Date: 9<sup>th</sup> December 2024  
Our Ref: 20050384  
Your Ref: EN010135  
Site address: Stonestreet Green Solar

**RE: Application Ref. EN010135 – Solar photovoltaic array plus energy storage with associated infrastructure and grid connection, with a generating capacity greater than 50MW.**

This letter is written in response to the Stone Street Green Solar Written Representations request which are due on the 9<sup>th</sup> of December 2024. Kent Wildlife Trust's Written Representations expand on the comments made during the Relevant Representations, which were submitted in September 2024. Kent Wildlife Trust's remit includes impacts to biodiversity within Kent. We have reviewed relevant documents submitted within the DCO against national and local legislation and policy. A summary of our main concerns is described in the box below, with more detailed comments in the main body of the letter.

drawing no: **5535-LLB-XX-XX-DR-Ec-0064**
 drawing title: **Environmental Statement Figure 9.9**
Important Hedgerows

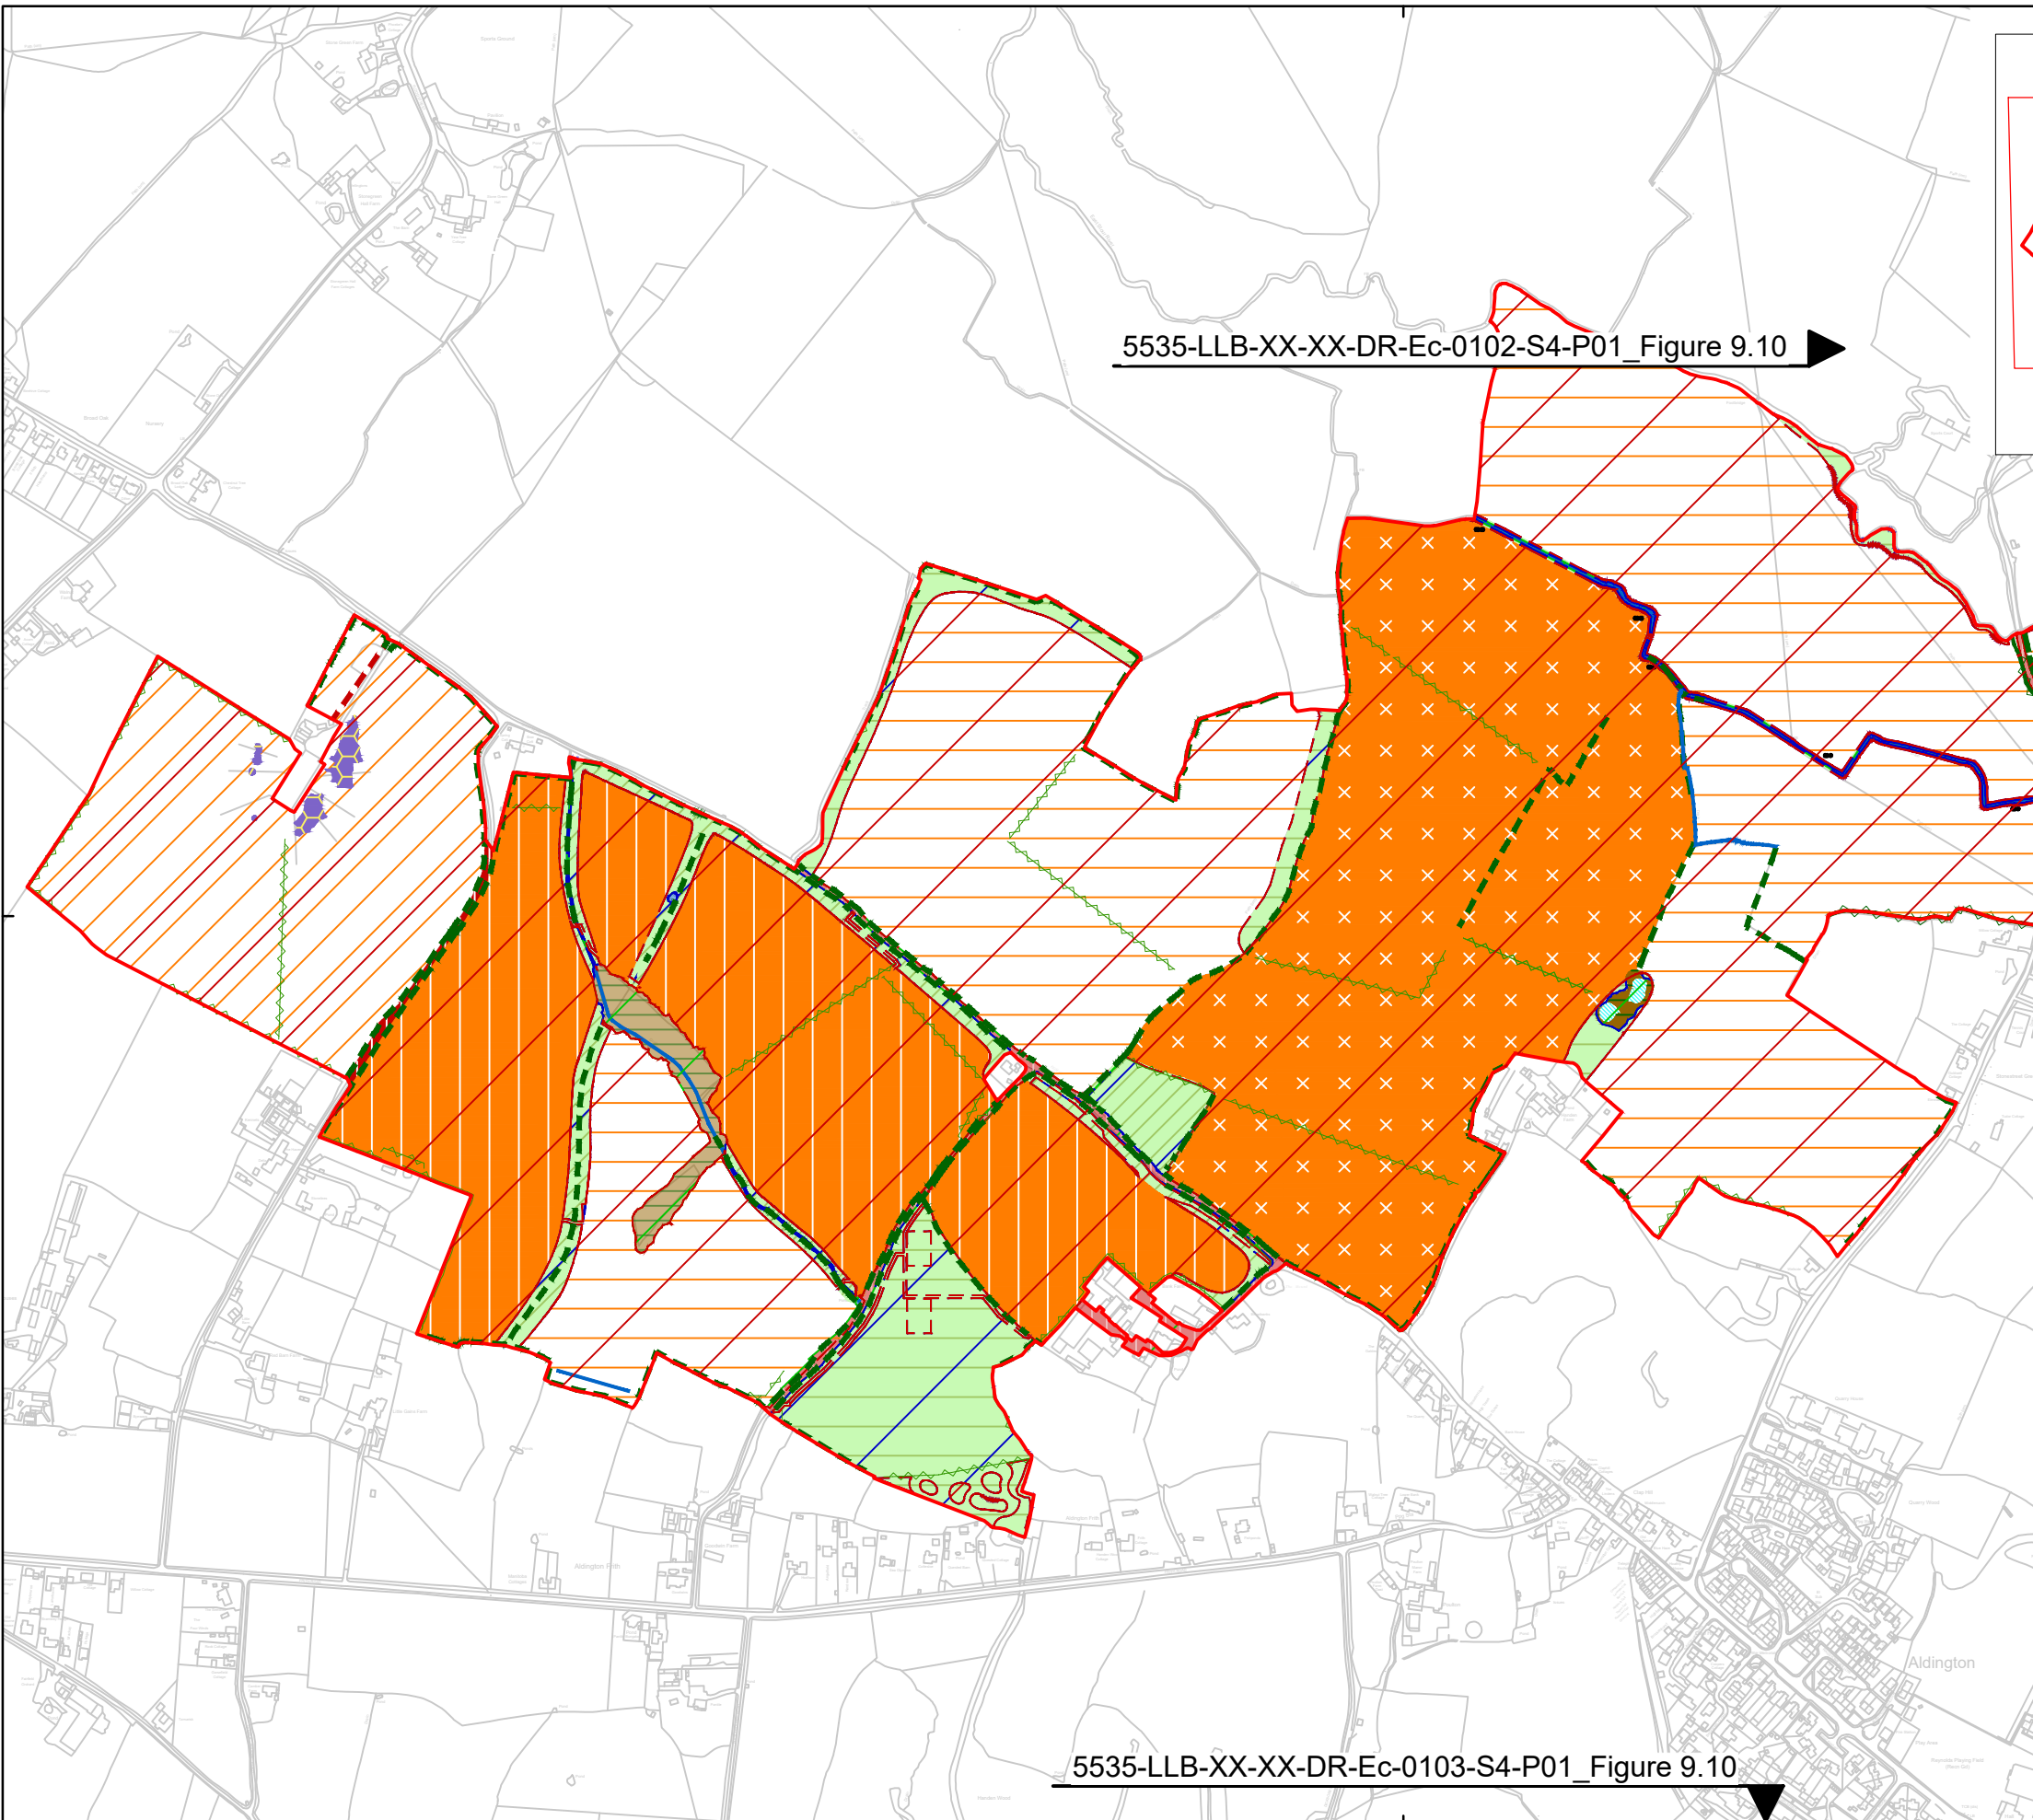
Minimal detail has been provided in the outline CEMP (Document ref. 7.8) on the protection measures to be employed for hedgerow and boundary habitats during construction. It is unclear whether sufficient space will be provided between the hedgerow and the security fencing. The details provided within the submission have not considered the reduced separation distance that will occur over time as the width of the hedgerow is allowed to increase to be of maximum benefit to a range of bird species. This is of particular concern given the impacts of the development on species which utilise the hedgerow such as yellowhammer. We also have concerns that designated access tracks will be in use along sections of the hedgerow during the operational phase. It is unclear from the supporting documents, including the works plan (document ref. 2.3), where these access tracks will be and their distance from the root protection areas of the hedgerow.
